Matthew Rosel - Submission Details for

Submission for Job: #6010 SSD 6010 - One Residential Building (Student Accommodation) within Darling Drive Plot
https://majorprojects.affinitylive.com/?action=view_job&id=6010

SSD 6010 - One Residential Building (Student Accommodation) within Darling Drive Plot

23 July 2013

SHADOW DIAGRAMS: PERSPECTIVE, SHOWING THE PEAK, WINTER SOLSTICE

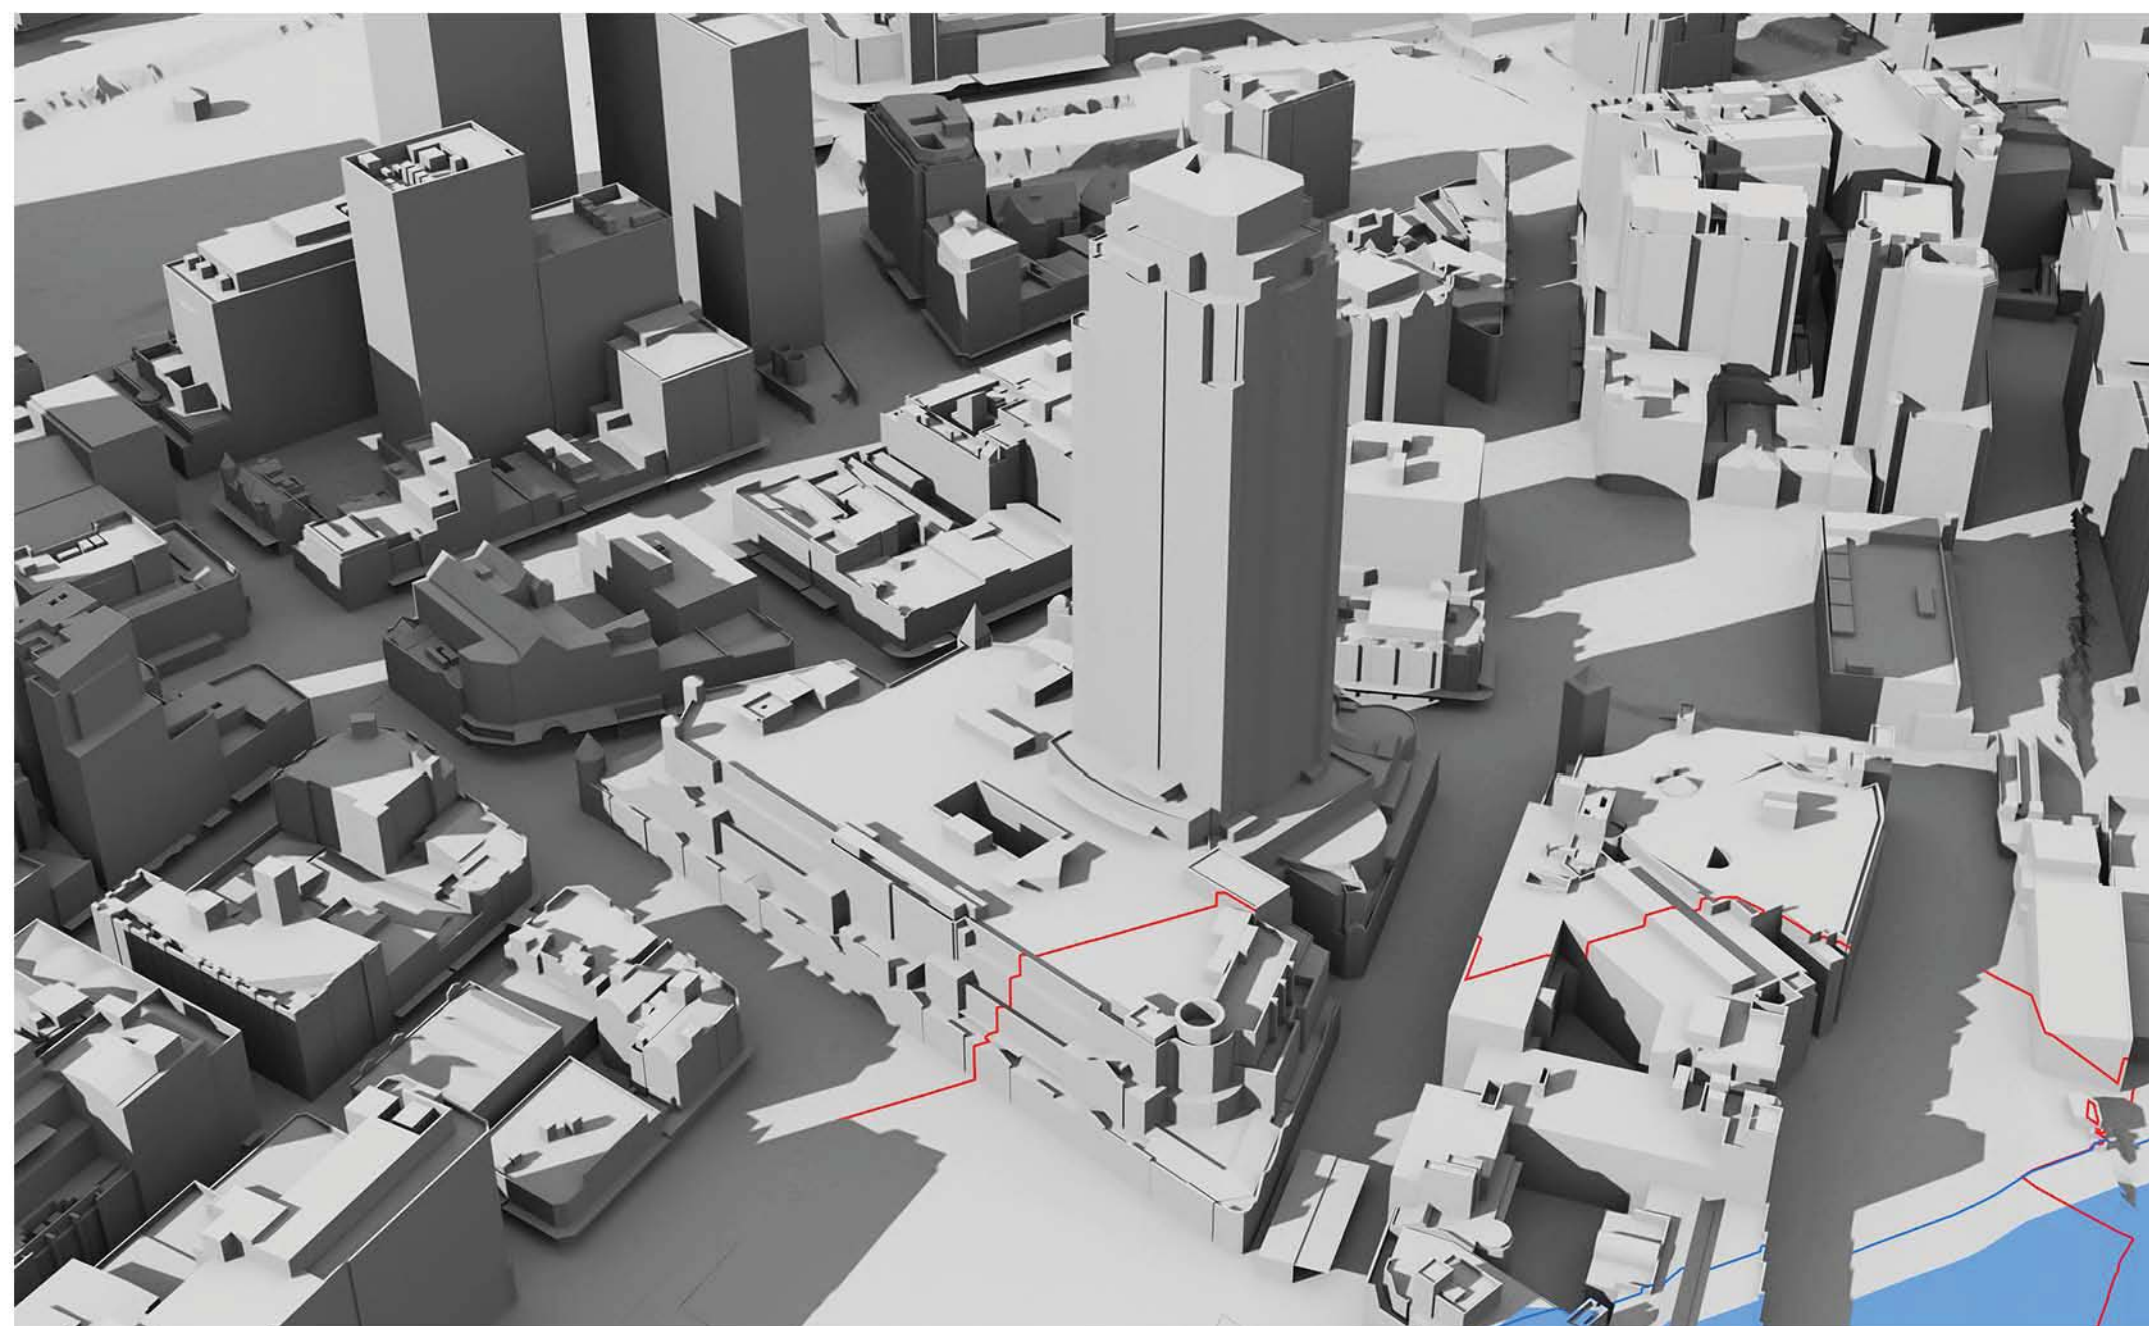
At 9am, 10am and 11am the west façade is totally in shadow due to other parts of The Peak building itself.

It can be concluded that some single aspect apartments on the west façade and some south-west dual aspect corner apartments currently receive less than 2 hours direct sunlight to habitable rooms and 50% of the private open space between 9am and 3pm on 21 June.

At 9am, 10am and 11am the west façade is totally in shadow due to other parts of The Peak building itself.
